Our ref: Q210454
Your ref: BC080001
Email: [REDACTED]@quod.com
Date: 4 August 2021

Application by London Resort Company Holdings for an Order Granting Development Consent for the London Resort

Clarifications and Additional Assessment Information Requests

Appendix TA - R

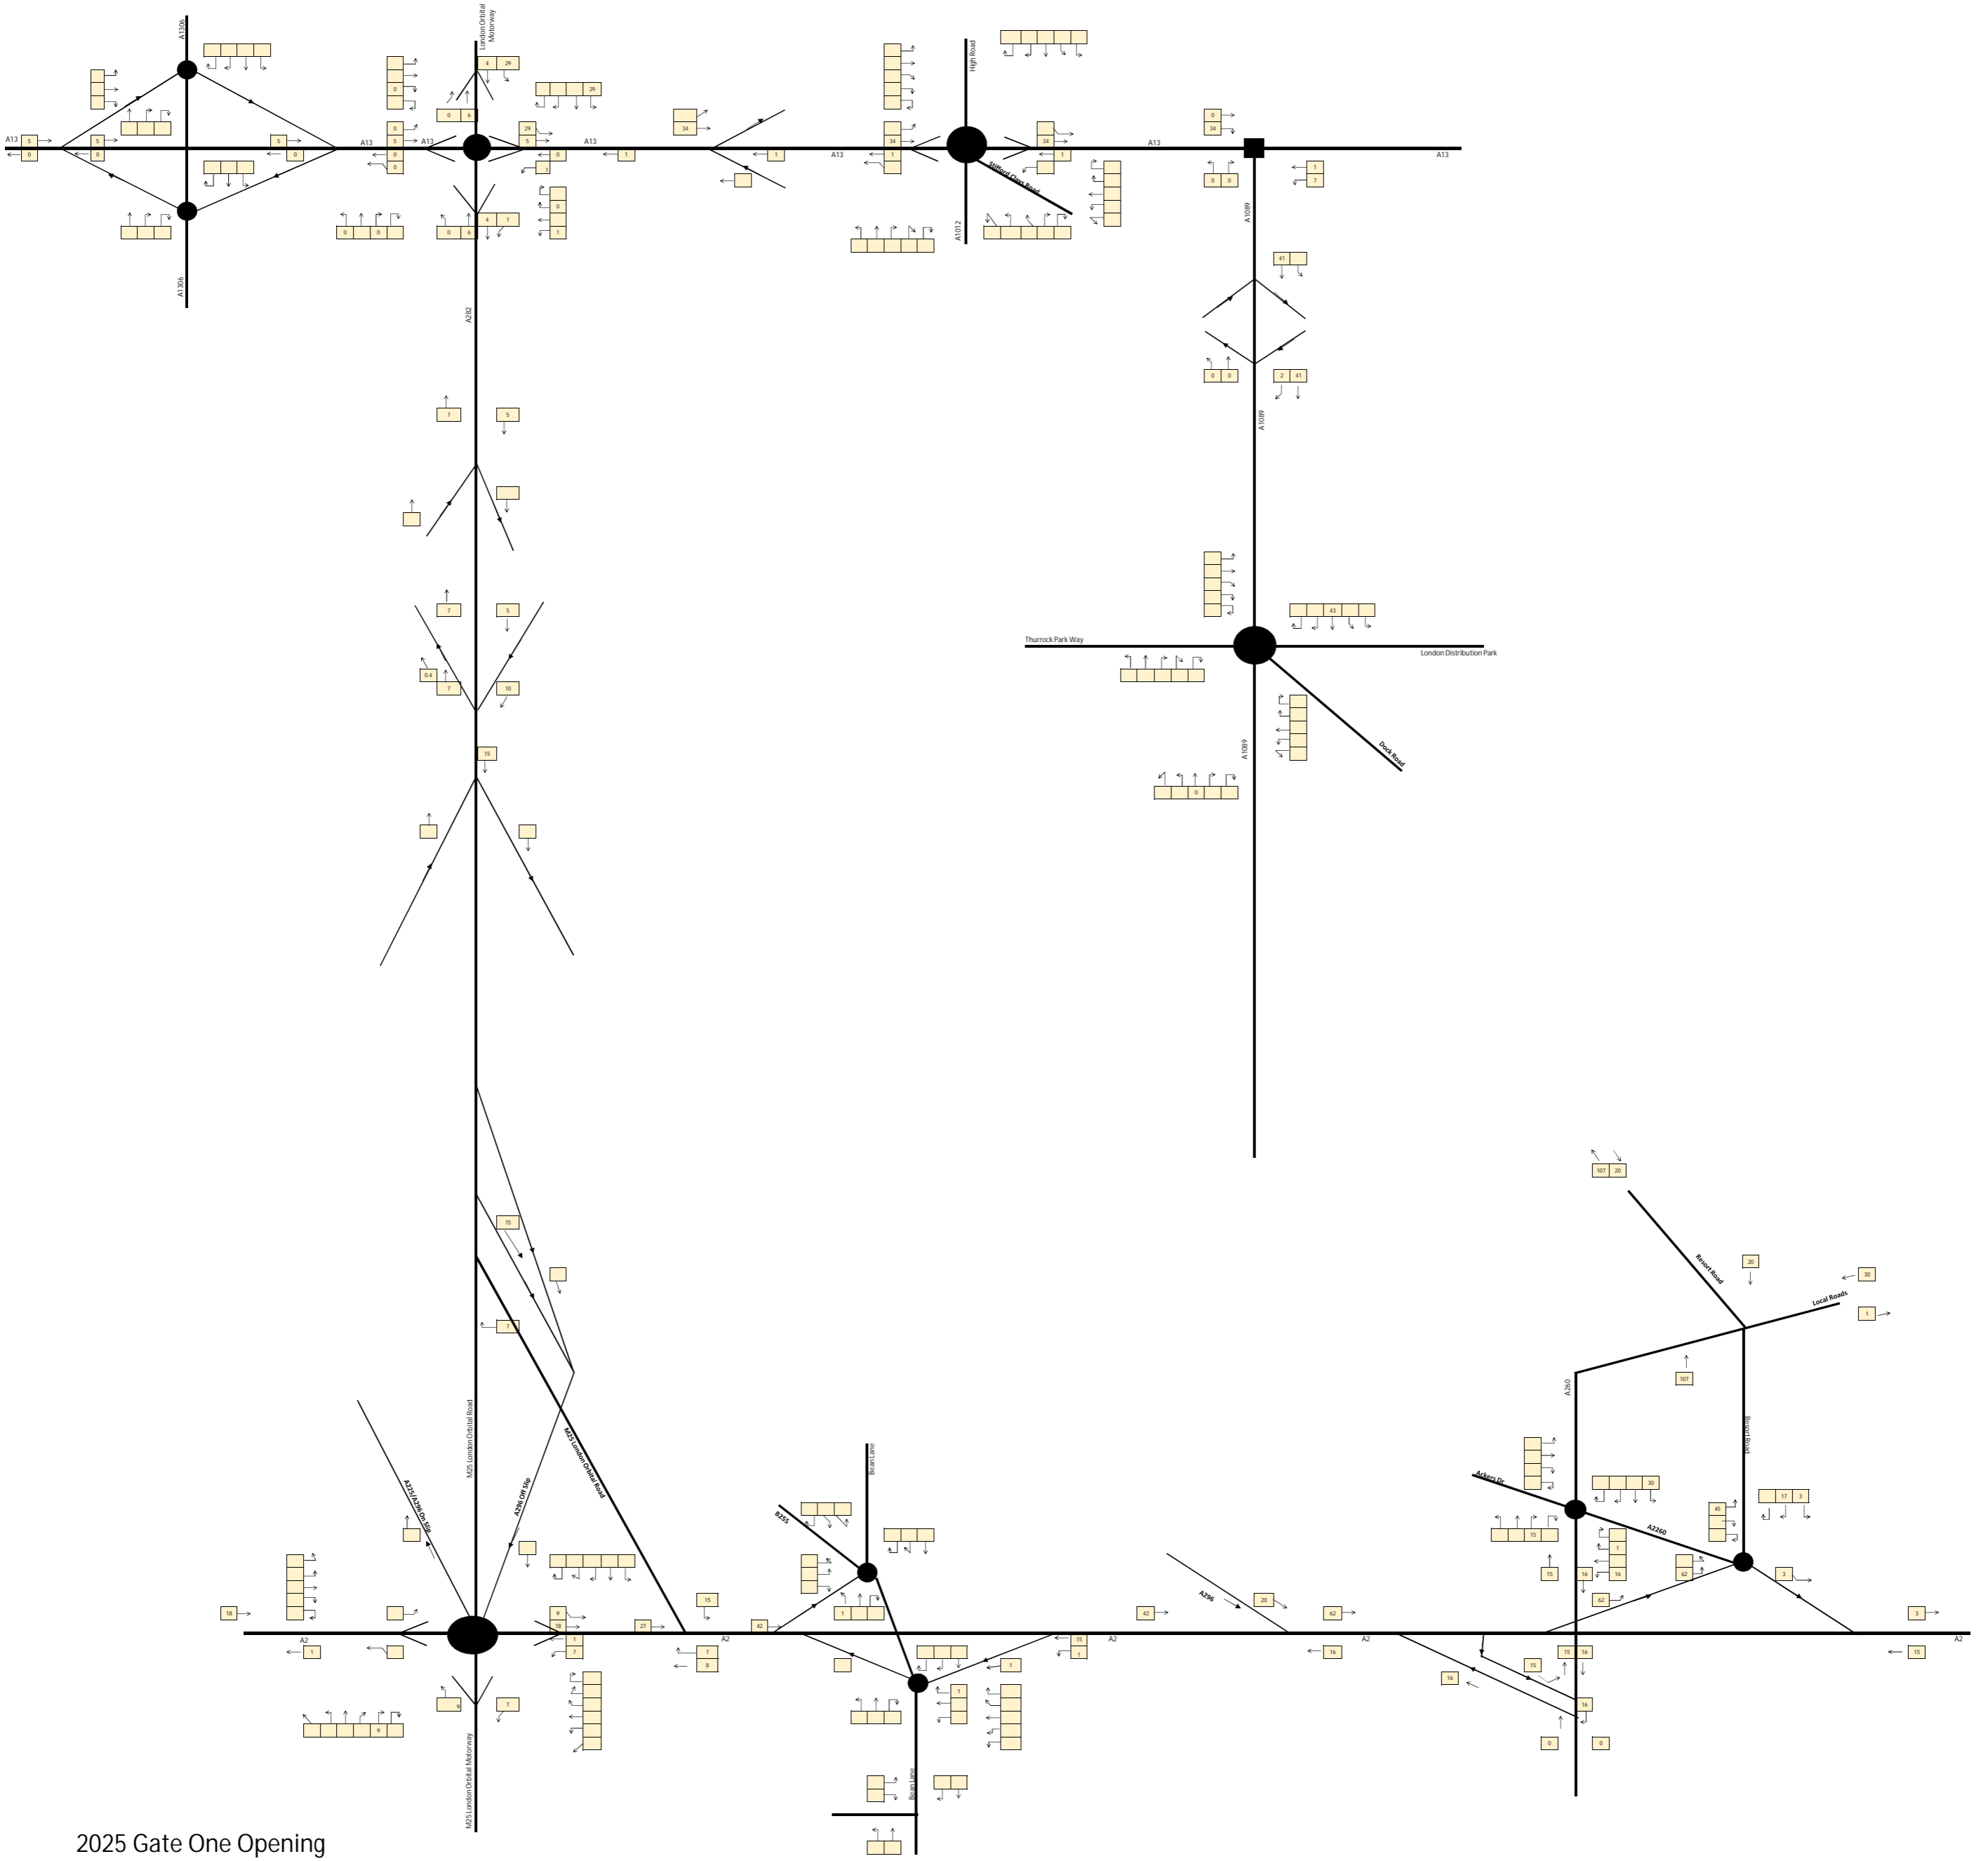
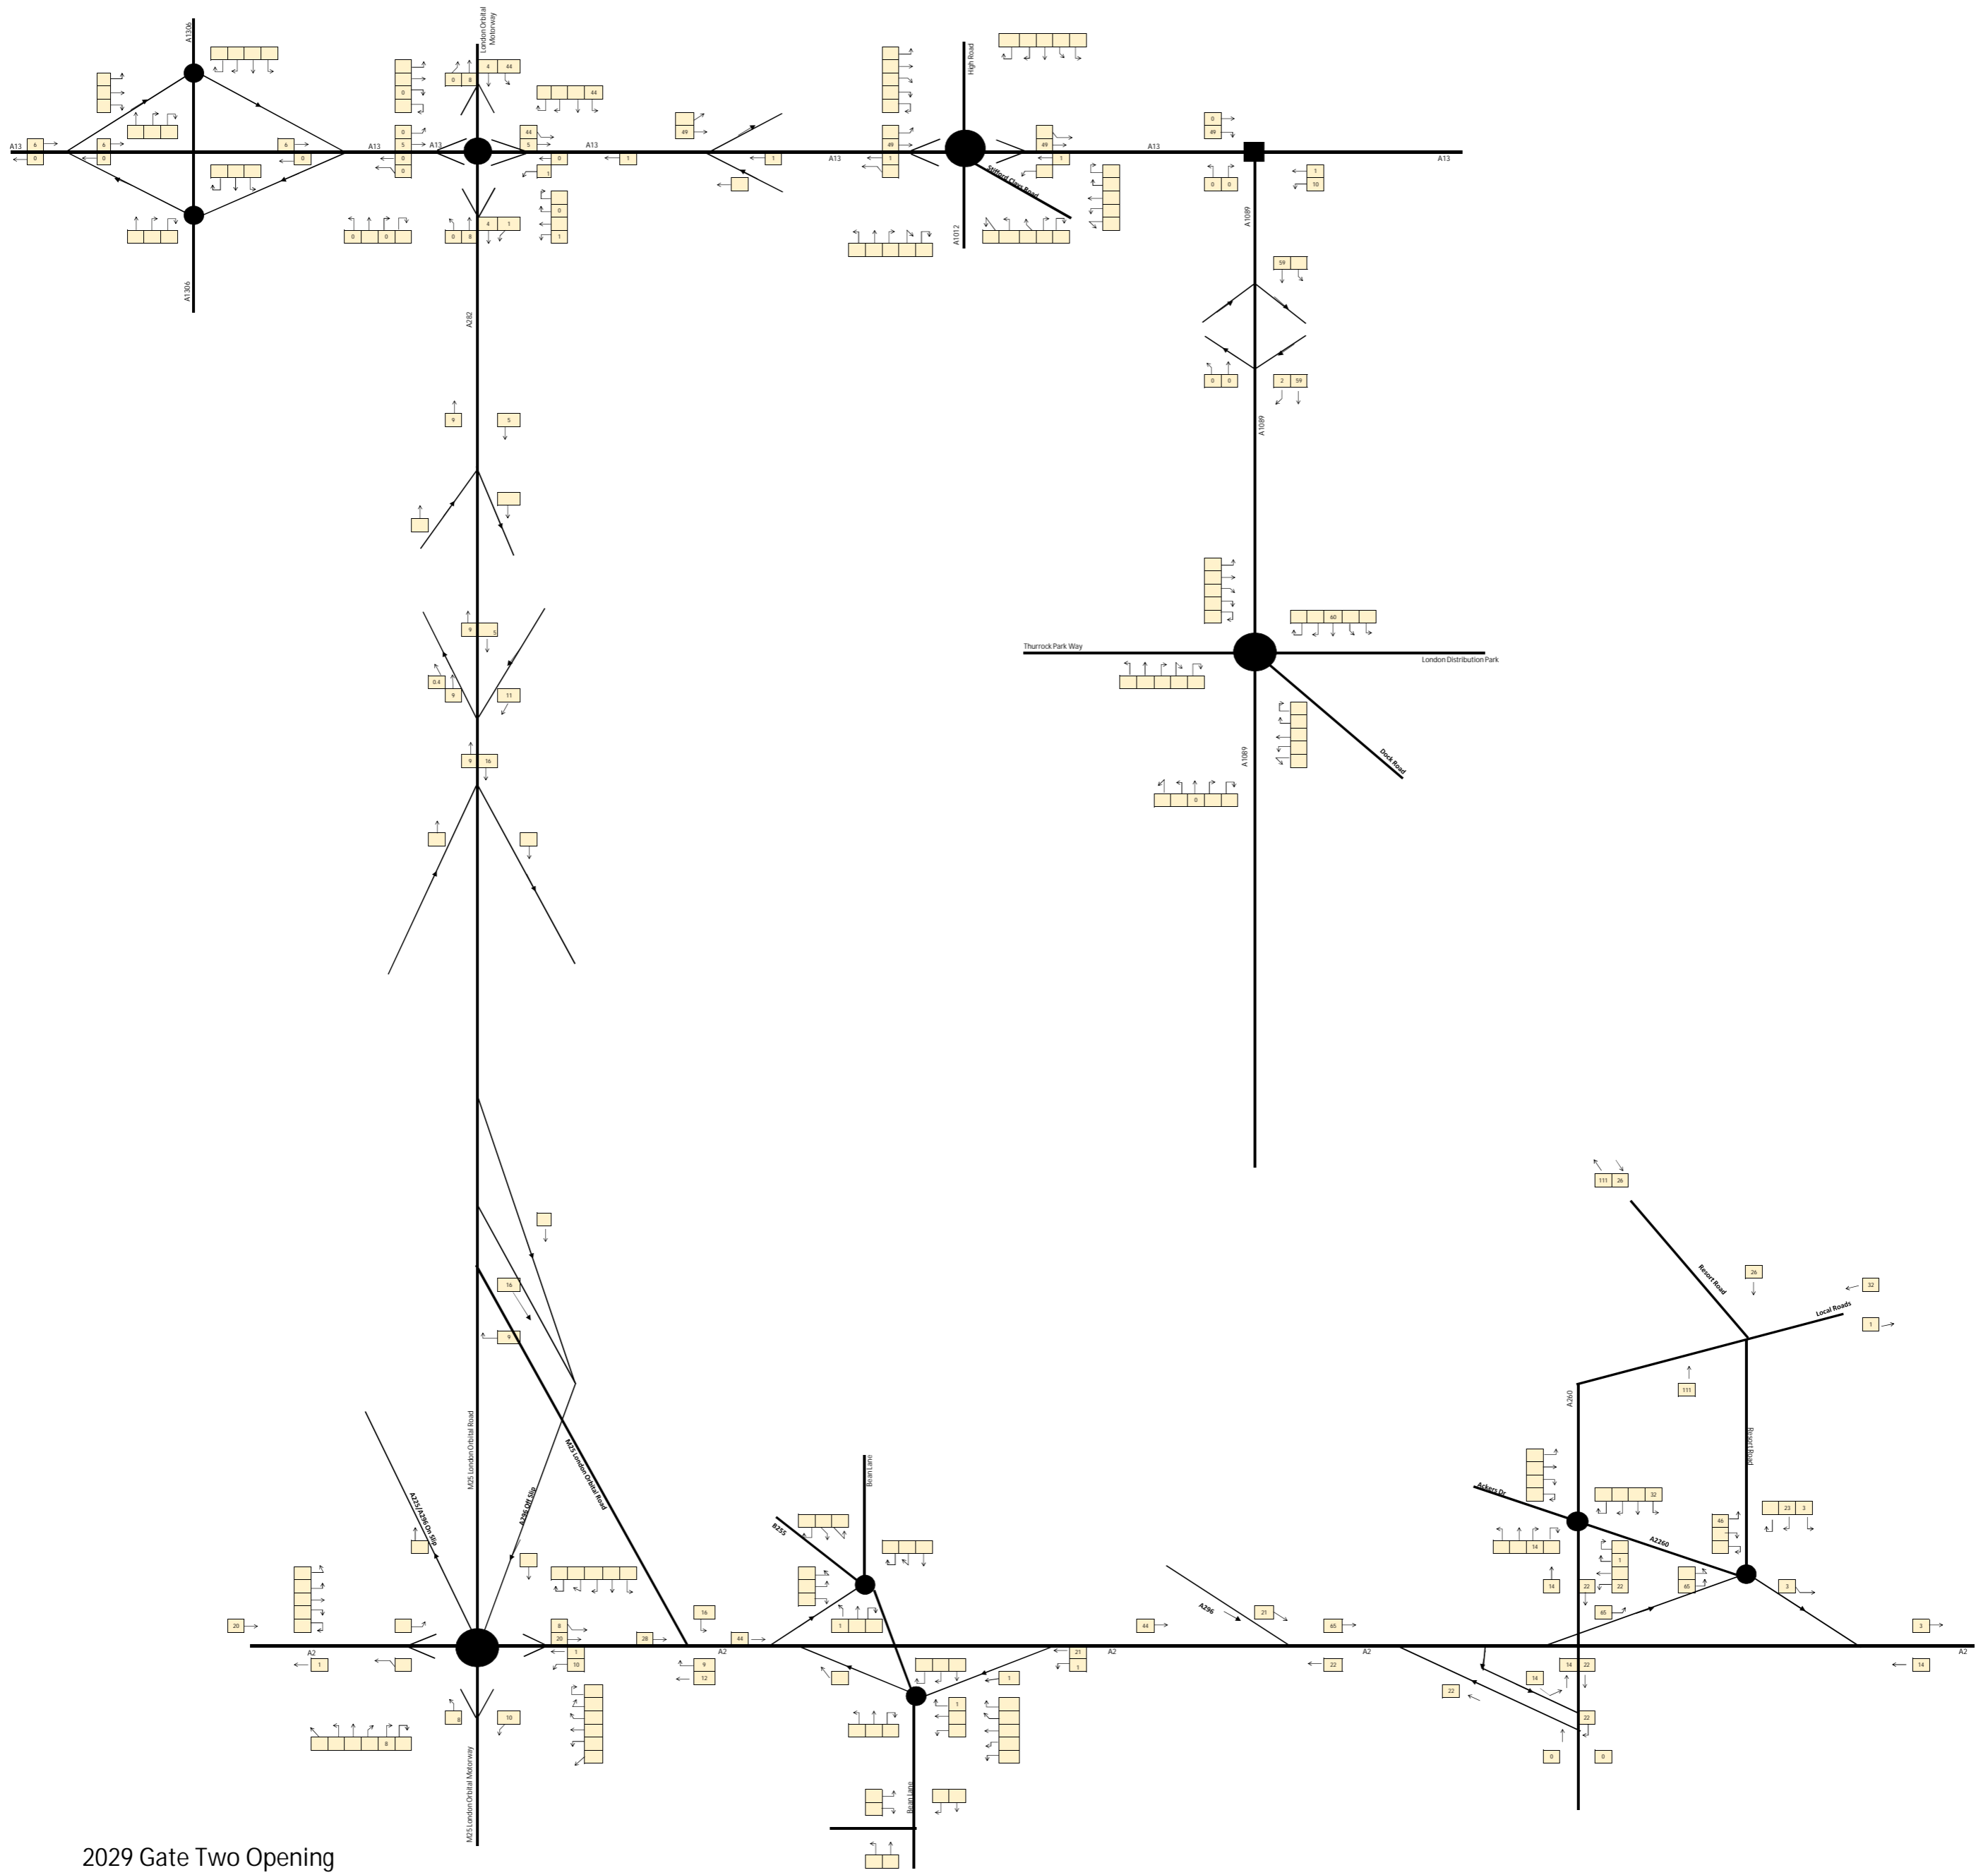
7.	The traffic flow diagrams in Appendix TA-R of the Transport Assessment (APP-116 6.2.9.1 ES Ap 9.1) do not show where traffic routed east on the A2 travels to. This is a significant concern and further modelling is required to enable the Authorities to assess the impact on the network and ensure appropriate mitigation is secured.		✓
